Project site 43/44 Sydney Olympic Park
SOPA Design Review Meeting Stage 1 DA
3pm 29th of March 2012

Exhibition of Environmental Assessment for Mixed Commercial and Retail Development (Stage 1) at 2 Australia Avenue, Sydney Olympic Park (Site 43/44) (MP10_0168)

drawing
DETAIL SECTIONS 1- 2

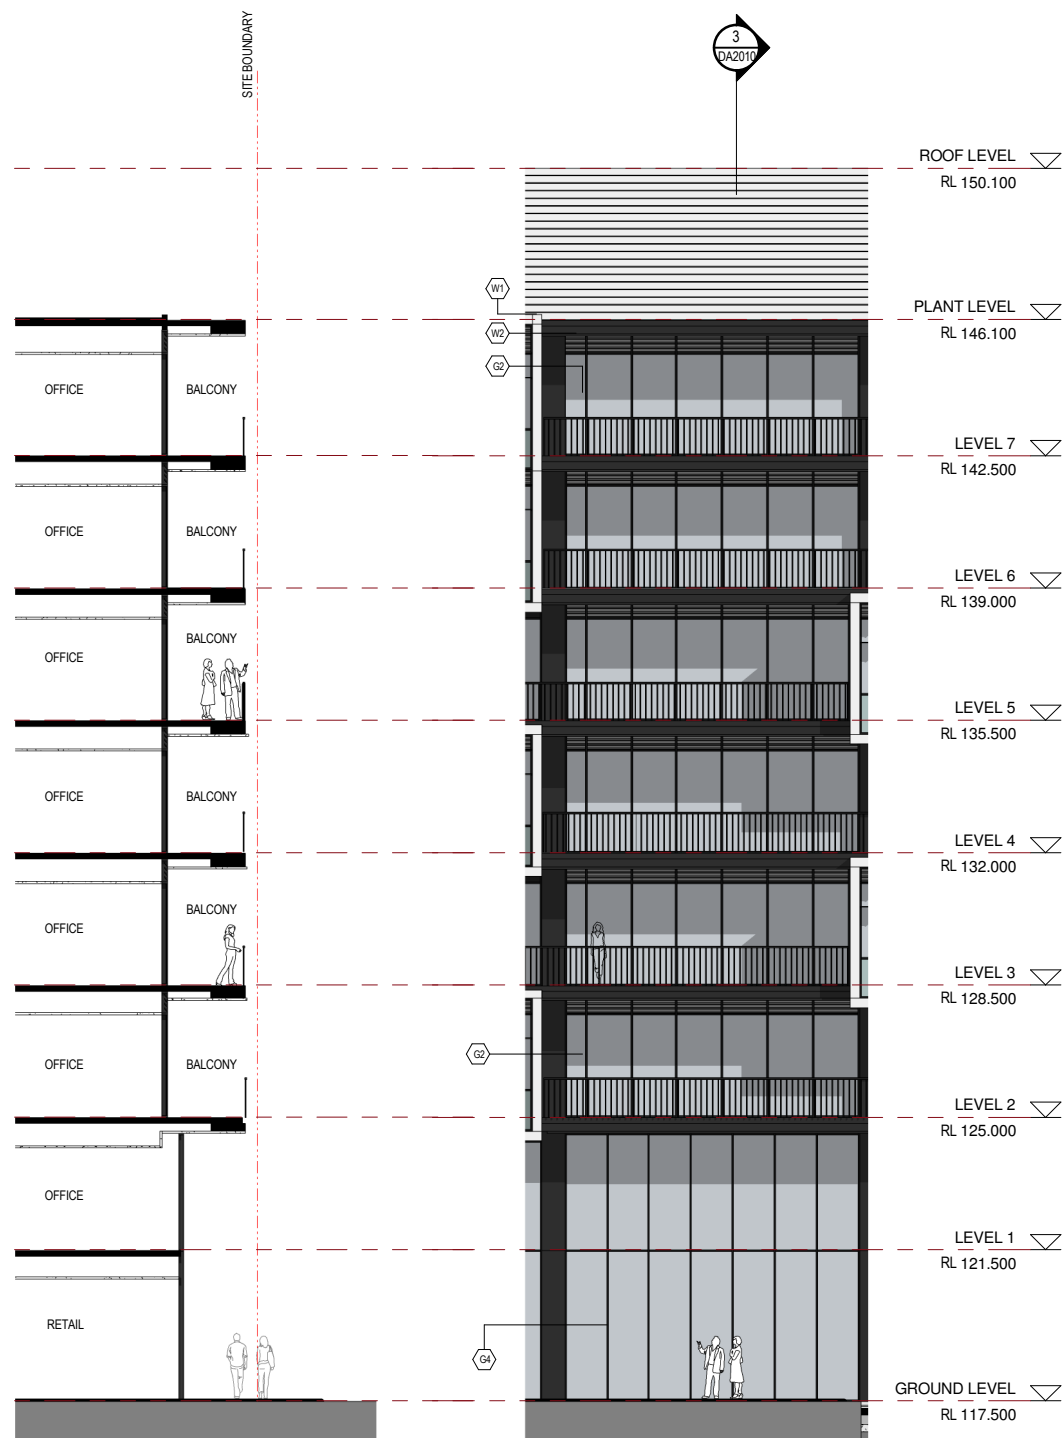
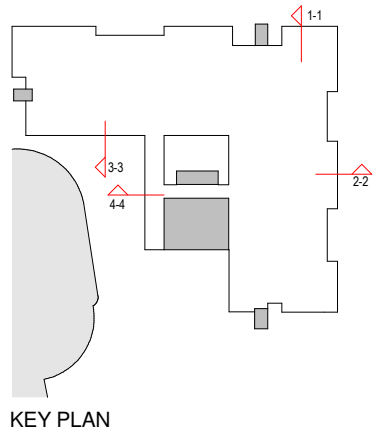
- The modified façade design with the staggered, expressed balconies generates an awkward street elevation that falls far short of the more sophisticated, calmer treatment of the competition winning entry, which featured continuous balconies on all levels, screened by a combination of light filtering devices.

- Instead of enlivening the elevations, the new darker toned materials and finishes are heavy and lifeless.
- Changes to the Herb Elliott undercroft design such as the removal of the Supermarket entry pavilion and the elliptical kiosk, now result in an overscaled, lifeless and potentially windswept space that will actively discourage public use. These concerns are amplified by the staging where, in Stage 1, the undercroft will be the primary public place.

2. Review the elevation design, including material and colour, to restore the lightness and simplicity of the original winning design, in particular the staggered blades at the recessed balconies should be reconsidered in favour of a more continuous façade screening similar to that proposed for the original design. Refer to comparative images at Attachment B.

1.3.1.2	<p>RB notes that character has been added by reducing the long, uninterrupted balconies and bronze anodized vertical to screens the balconies. Vertical painted concrete blade elements which were consistent with design competition were maintained as was the white terra cotta cladding.</p>	Note

1.3.1.5	<p>DV stated that the updated façade treatment was appropriate principle.</p>	Note	
1.3.2	b) Herb Elliot undercroft design		
1.3.2.1	<p>AW advised that the Café/Kiosk has now been included on the proposed layouts and that this area would be activated by seating</p>	Note

TYPICAL SECTION - GREEN WALL WITH HANGING SPECIES
PLANT TO FALL DOWN OVER FLOOR HEIGHT SPACE. TRELLIS FRAME NOT REQUIRED.

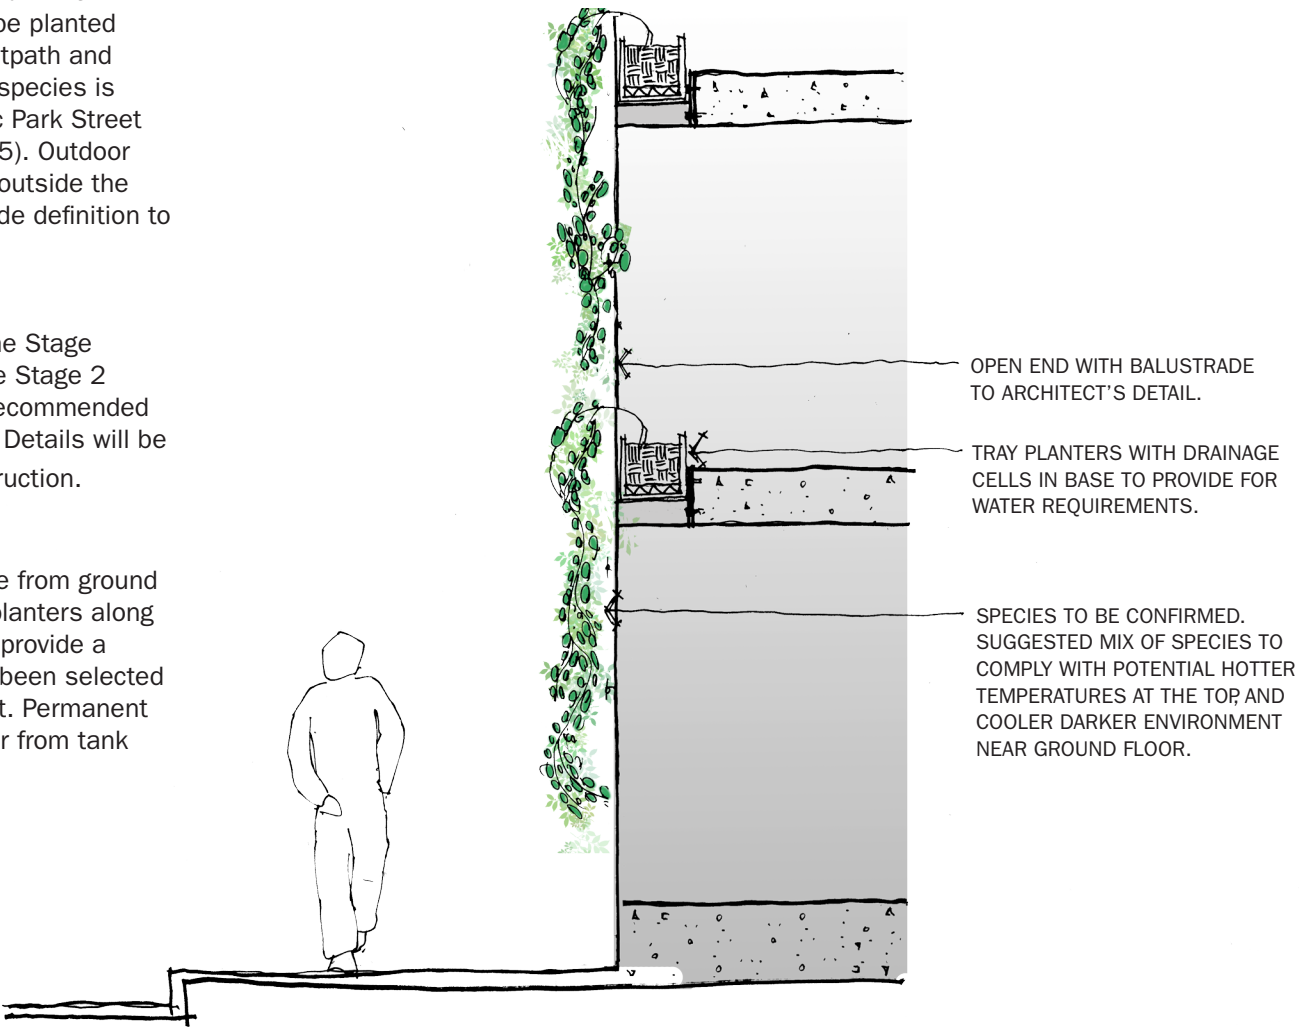
1.3.1.3	<p>RB also advised that the green wall had been further assessed and as it this was not operationally or maintenance efficient the long term result would be detrimental to the building.</p>	Note
